Permit Number: 031169

This is to certify that Wagner Lise R/Steve Bourey
has permission to 6' x 14'-6" addition and removing deck
AT 100 Alba St 179 G022001

Permit Nbr: 03-1169 Location of Construction: 100 Alba St Appl. Date: 09/19/2003
Status: Open Permit Type: Additions - Dwellings Issue Date: 07/02/2004
CBL: 179 G022001 District Nbr: 5 Estimated Cost: \$24,000.00 Date Closed: 04/09/2004

LISE WAGNER
 100 ALBA ST.
 EXISTING
 CONDITIONS
 1" = 10'
 ZONING - R-3

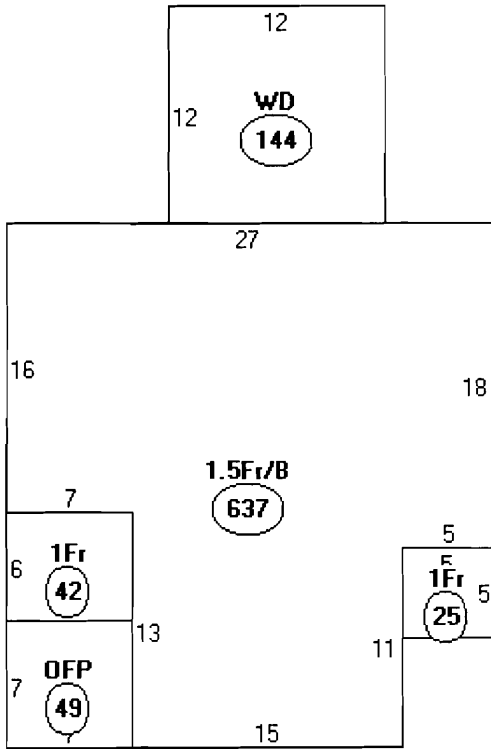
04/09/2004 resubmitted more info - still over on lot coverage - called builder and told we had to deny the permit and resubmit compliant plans.

02/04/2004 Met w/builder - need to redesign - still over on lot coverage.

10/15/2003 spoke w/builder - need to revise plans to meet setbacks and lot coverage.

06/04/2004 revised plan - conforms w/zoning - ok to issue.

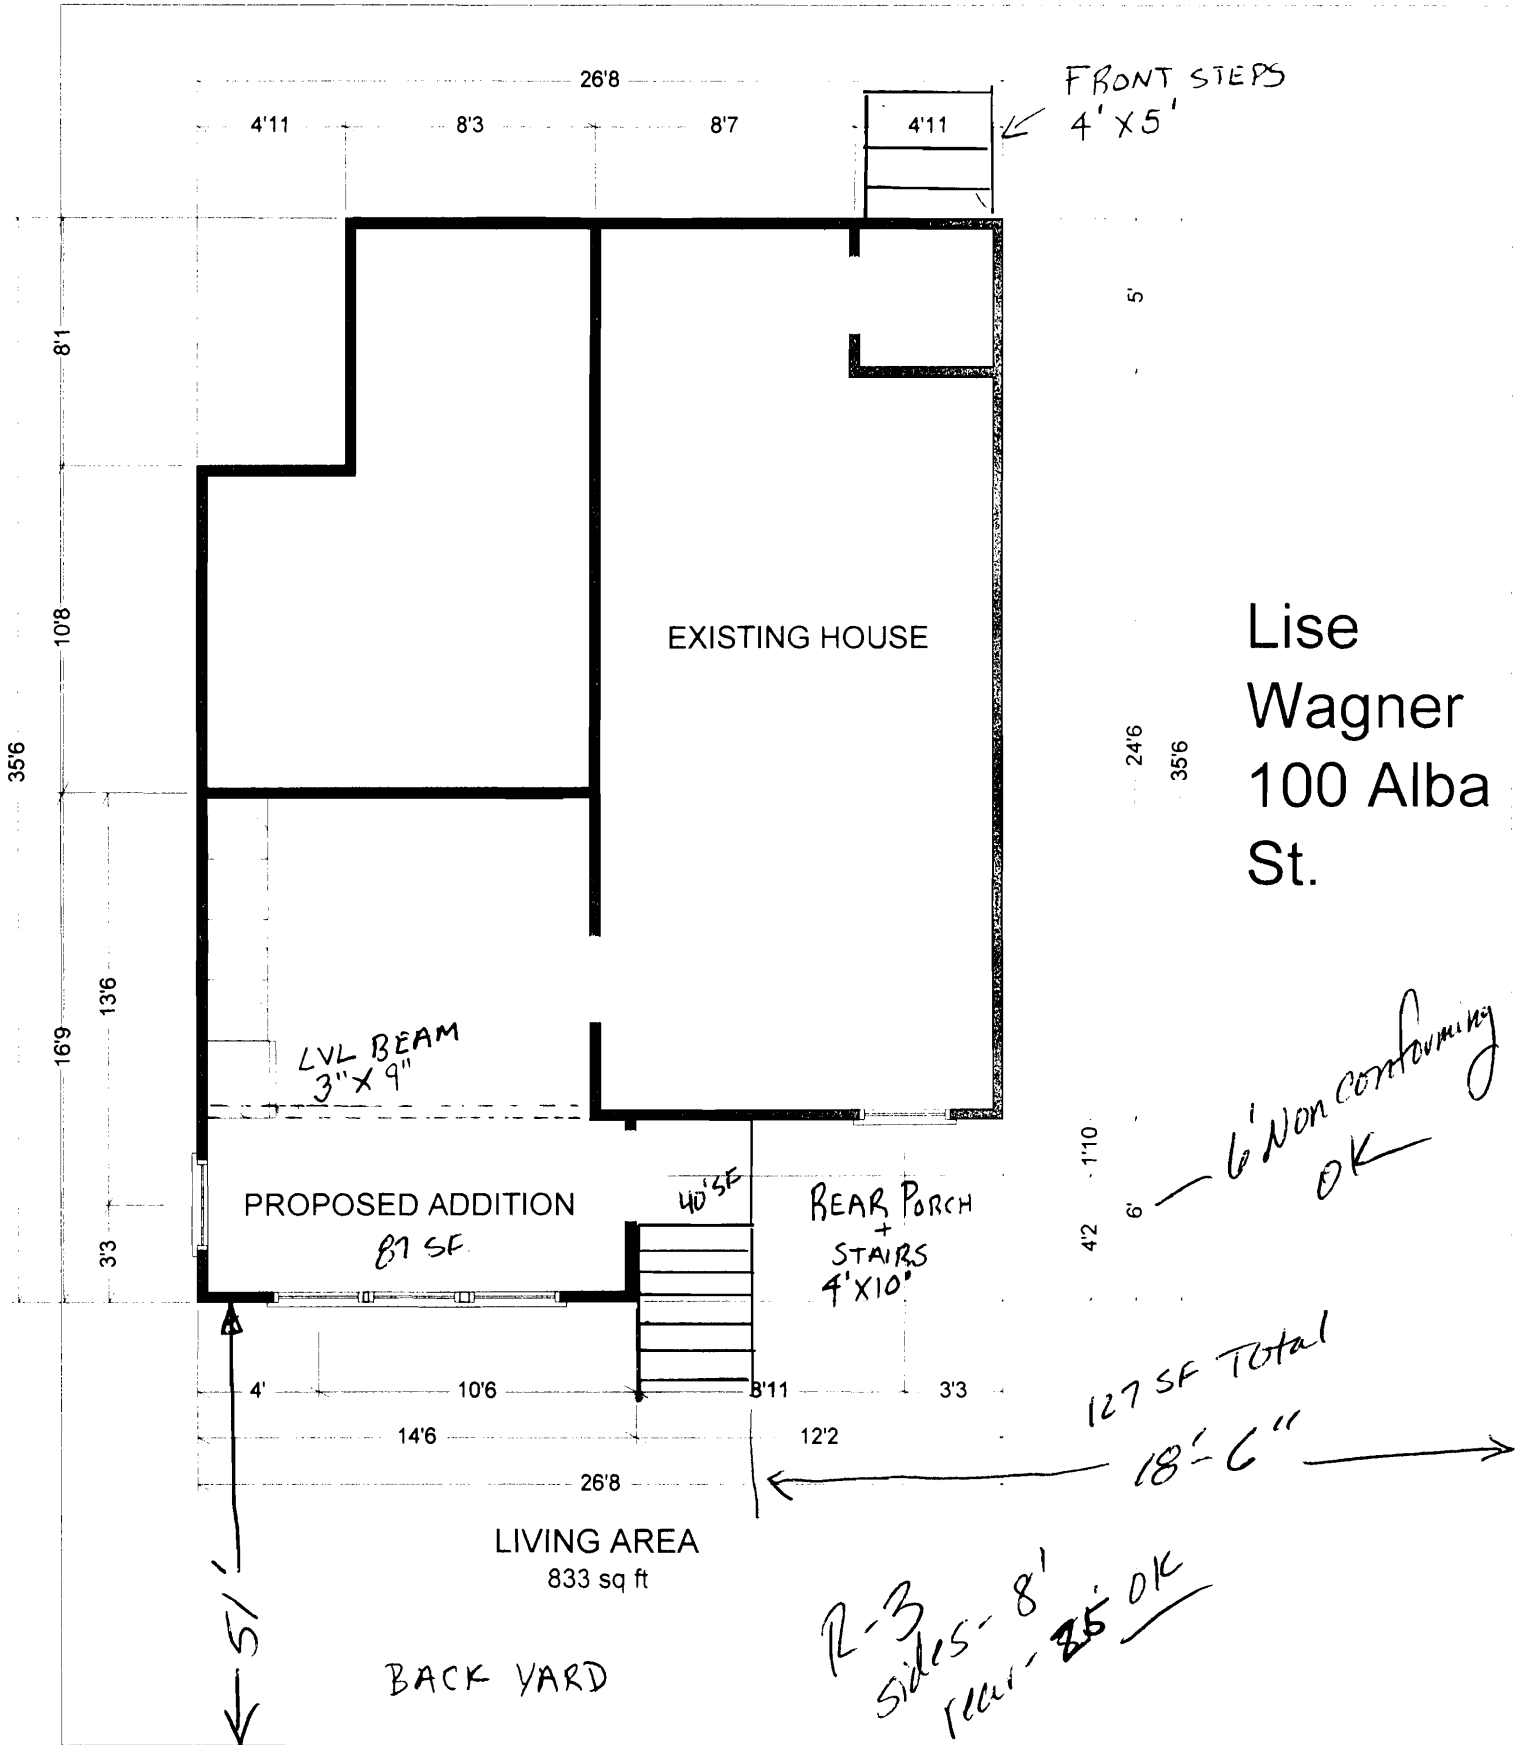
CONTINUOUS TRIPLE 2x10 HEADER ✓ OK

2x10" RIM JOIST ✓
